## 42 OBrion St - permit #01825

**Christina Stacey** <cstacey@portlandmaine.gov>  
To: jason@portcityarch.com

**Jason Pica** <jason@portcityarch.com>  
To: Christina Stacey <cstacey@portlandmaine.gov>

FLOOR PLANS

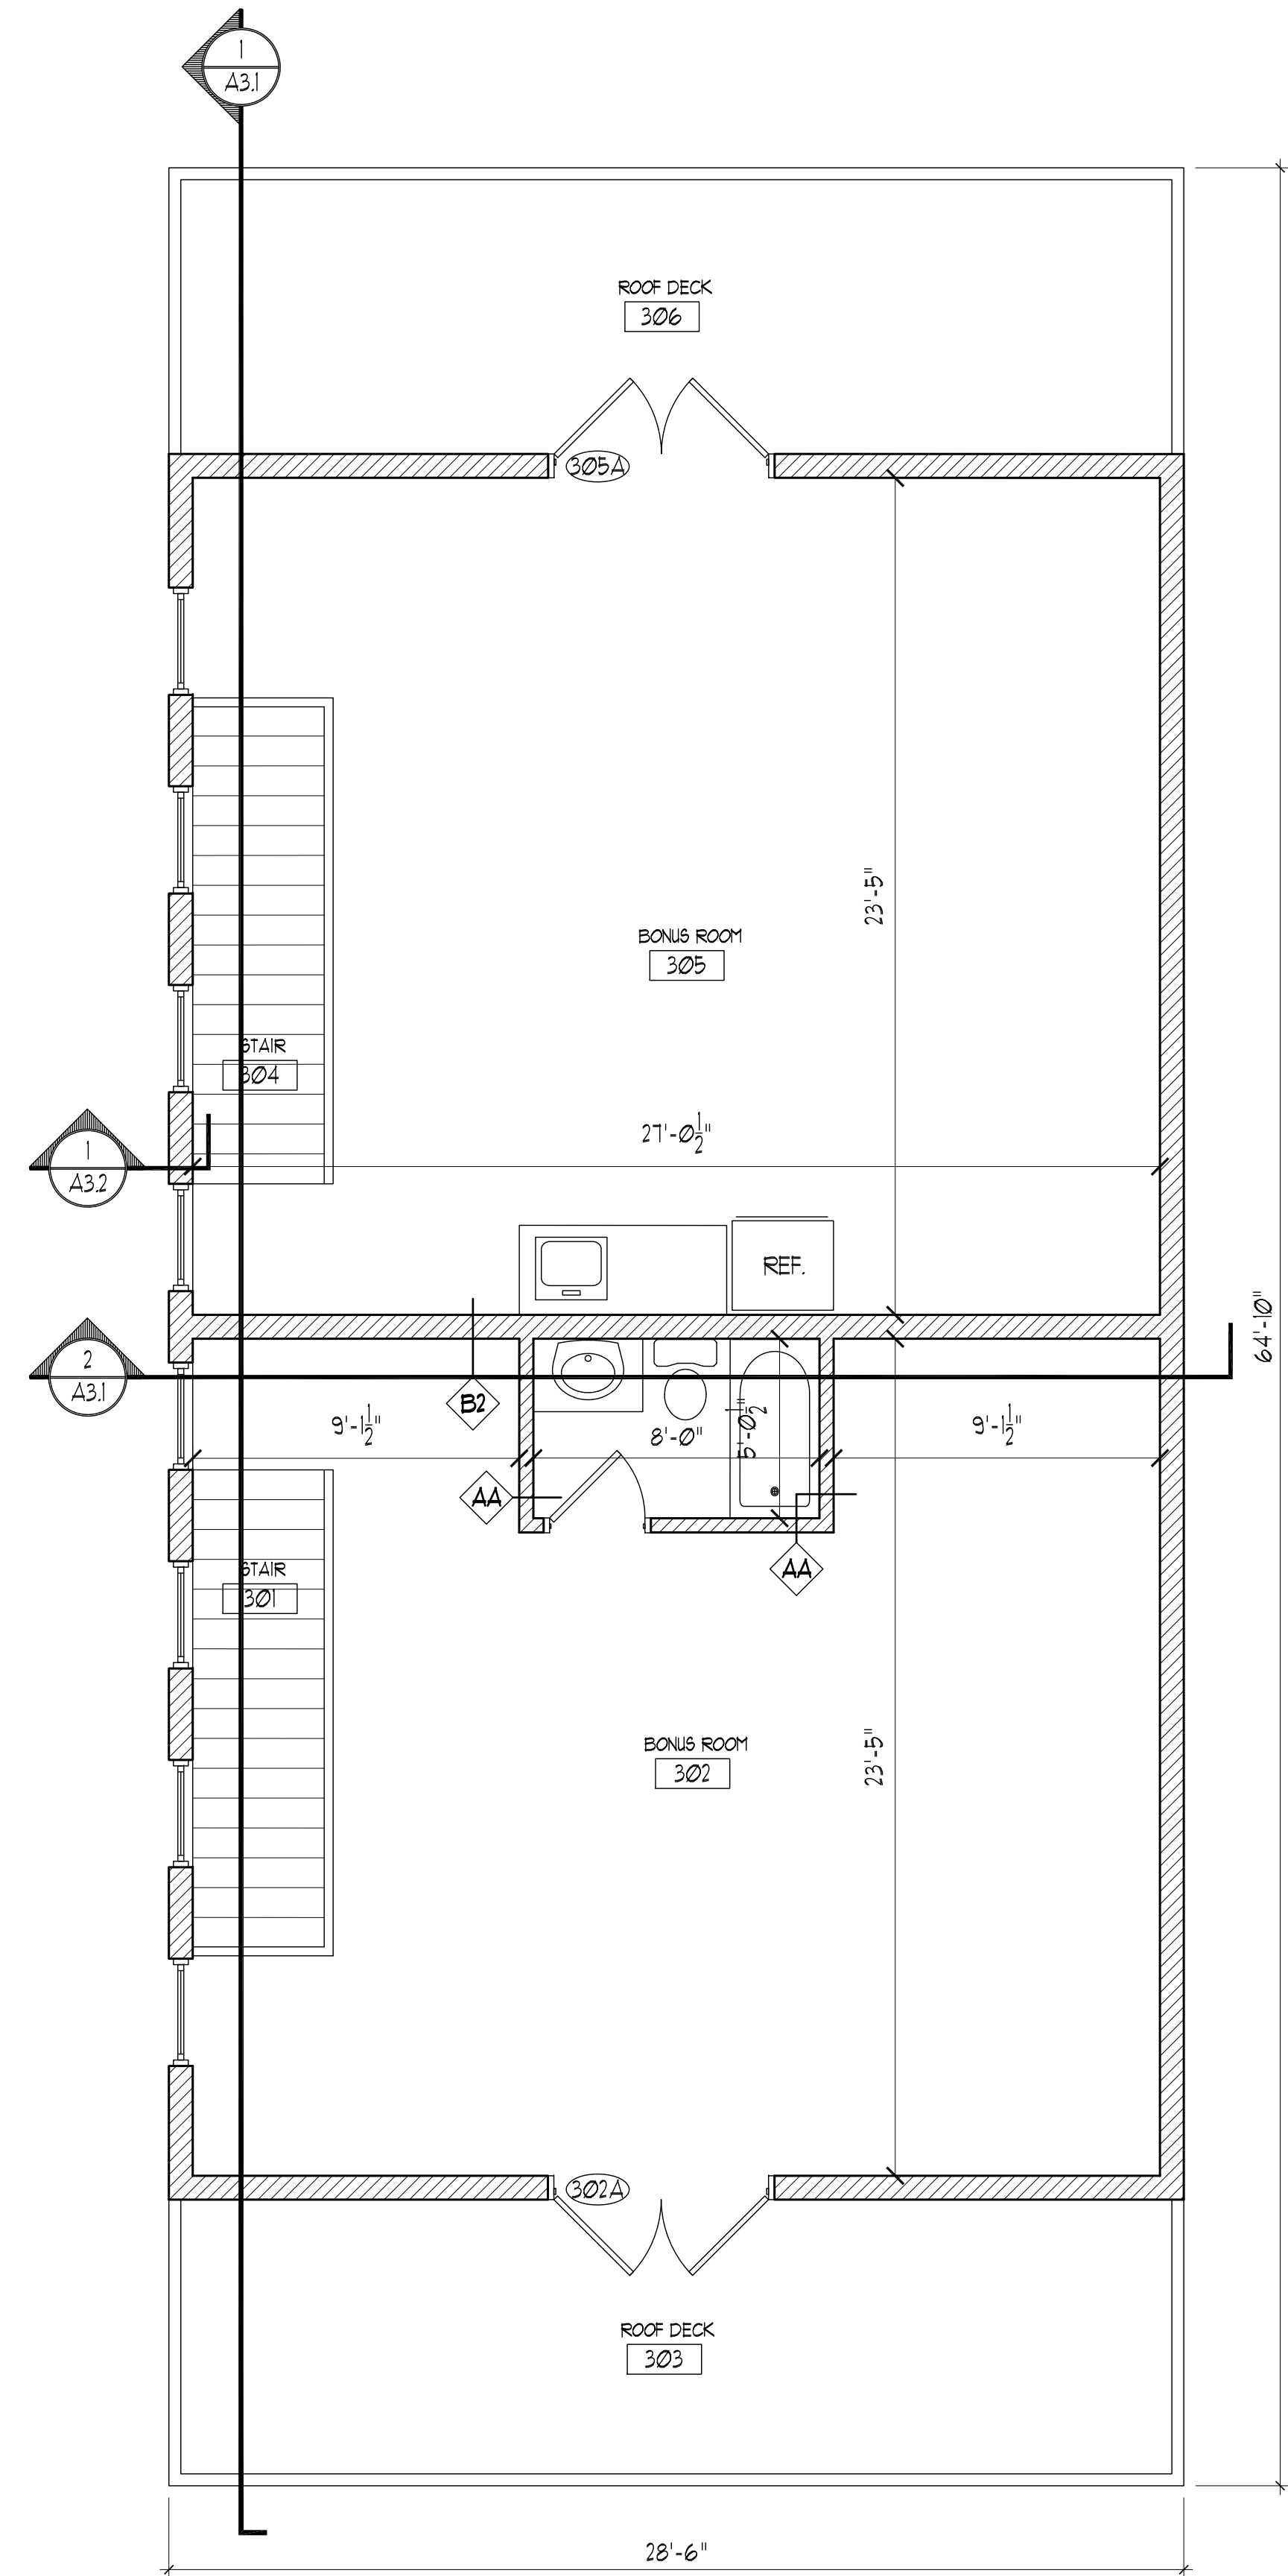
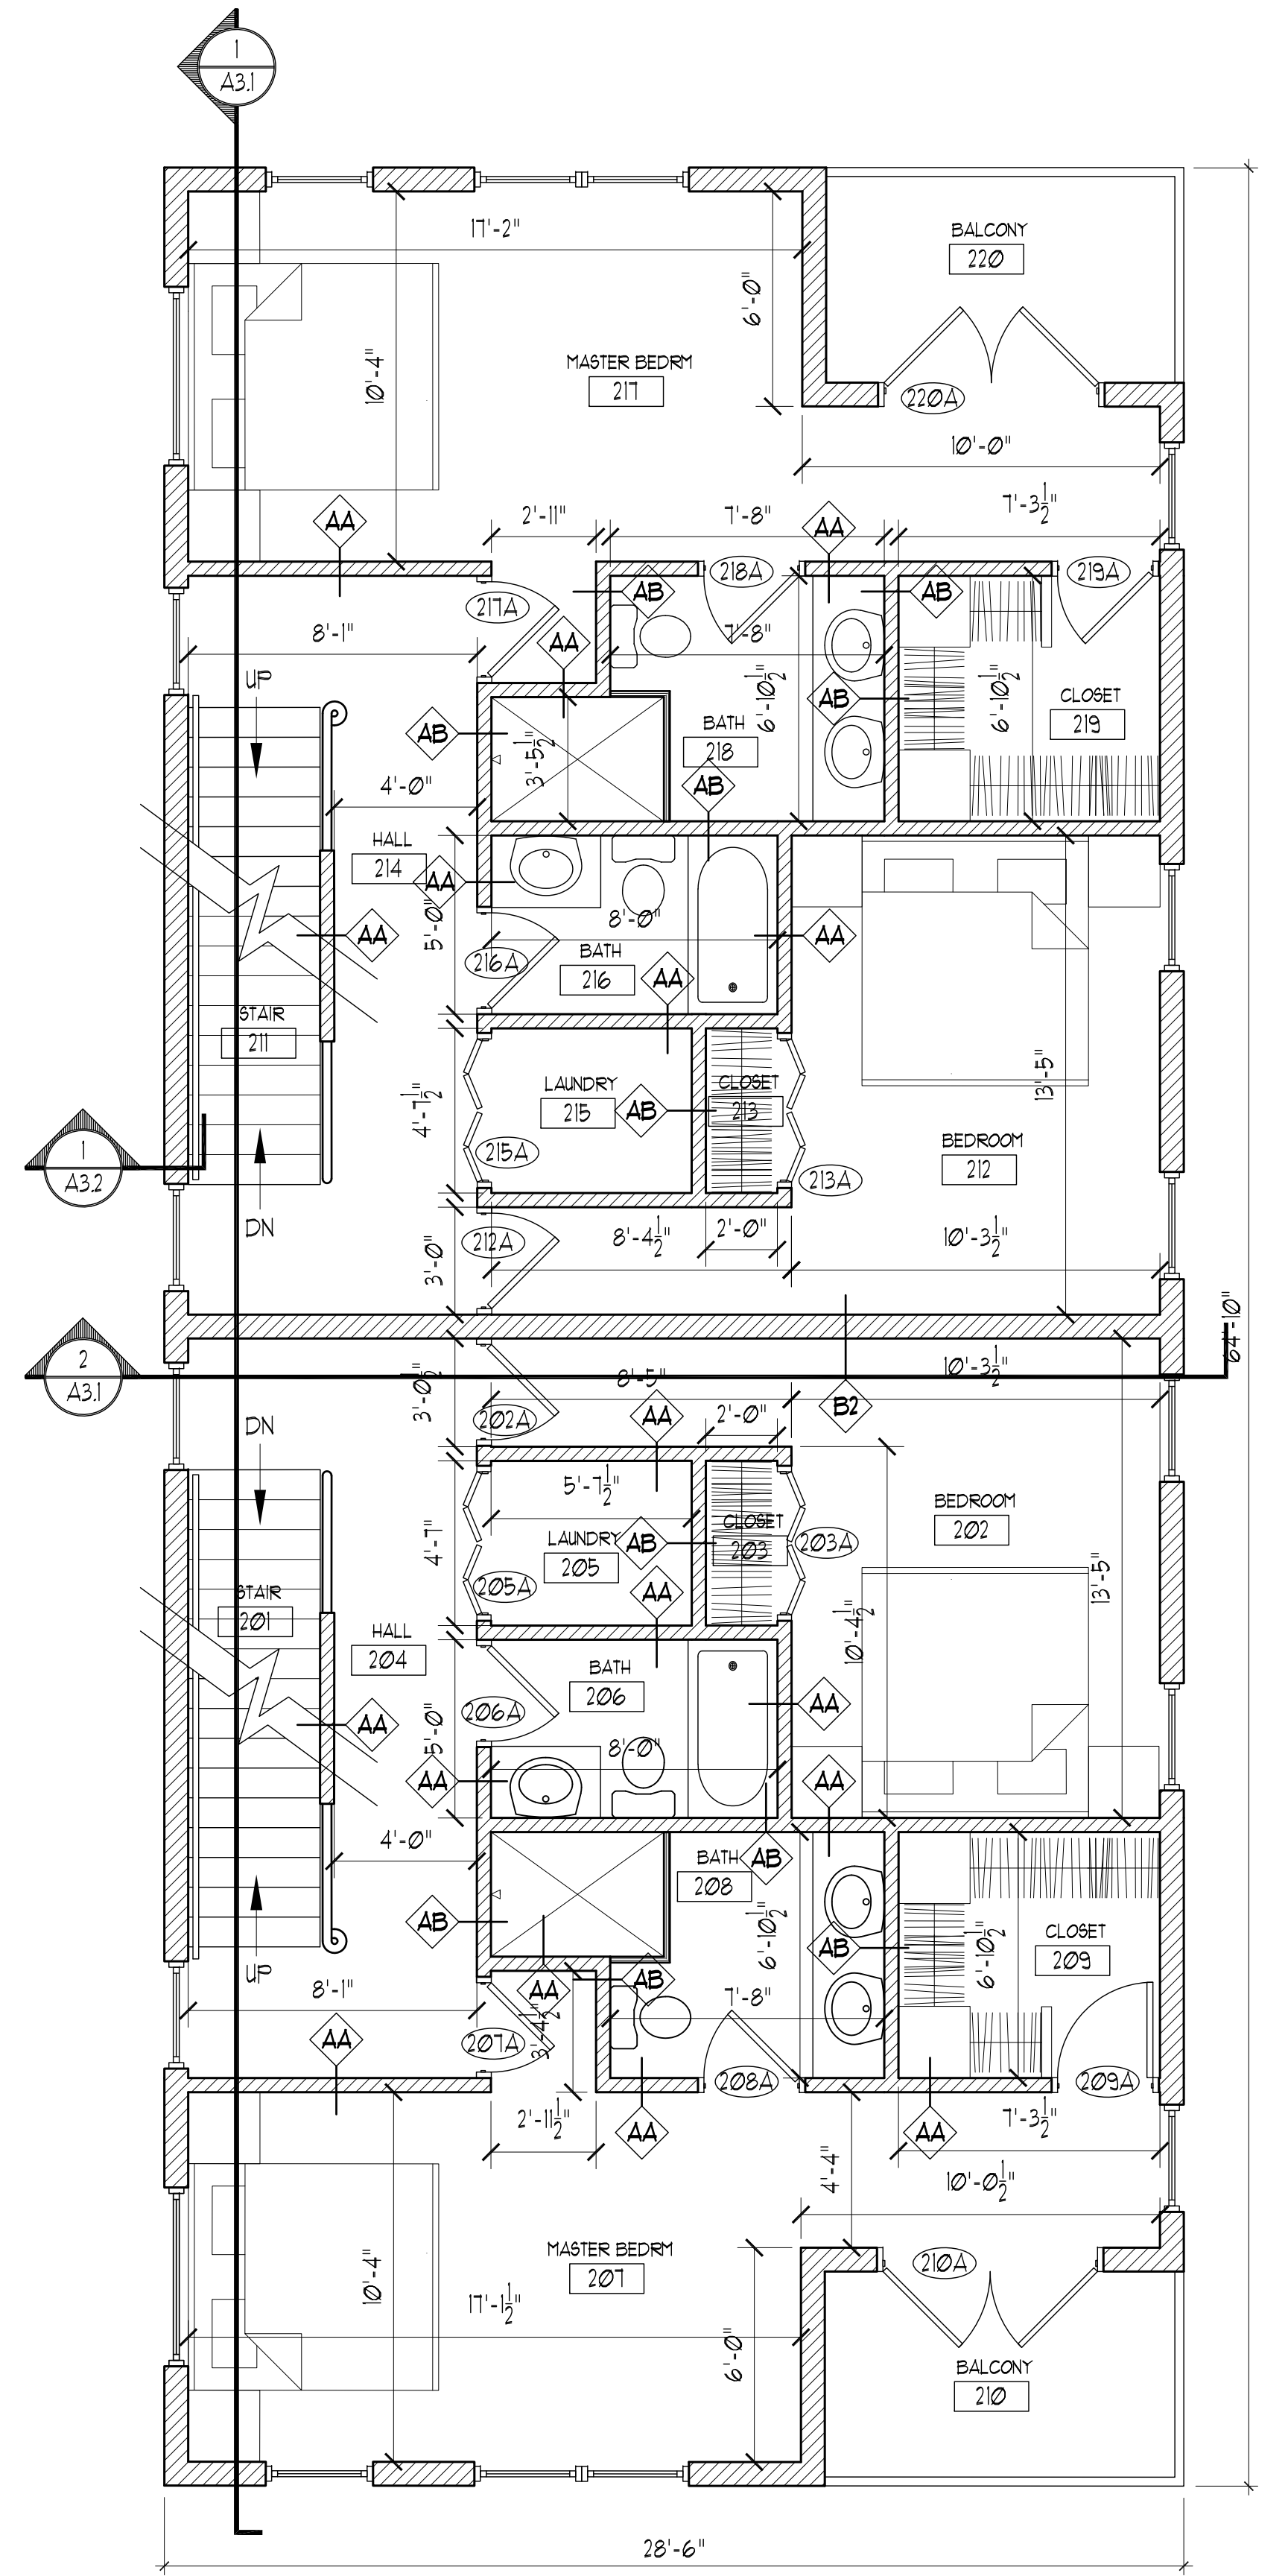
I forgot to mention one more issue on the plans. The bonus room in one unit shows what appears to be a bar sink and refrigerator. We are concerned about these types of items because of issues with people creating illegal dwelling units over time. We are OK with the bar sink and the small countertop, but the refrigerator appears to be full-size. Is this correct? We would limit this only to a mini-fridge size.

Good Morning, Please see attached for the New Elevations sheet A2.1 as well as a revised A1.2 for the third floor, I added a note that the fridge would be an under counter bar fridge. Thanks
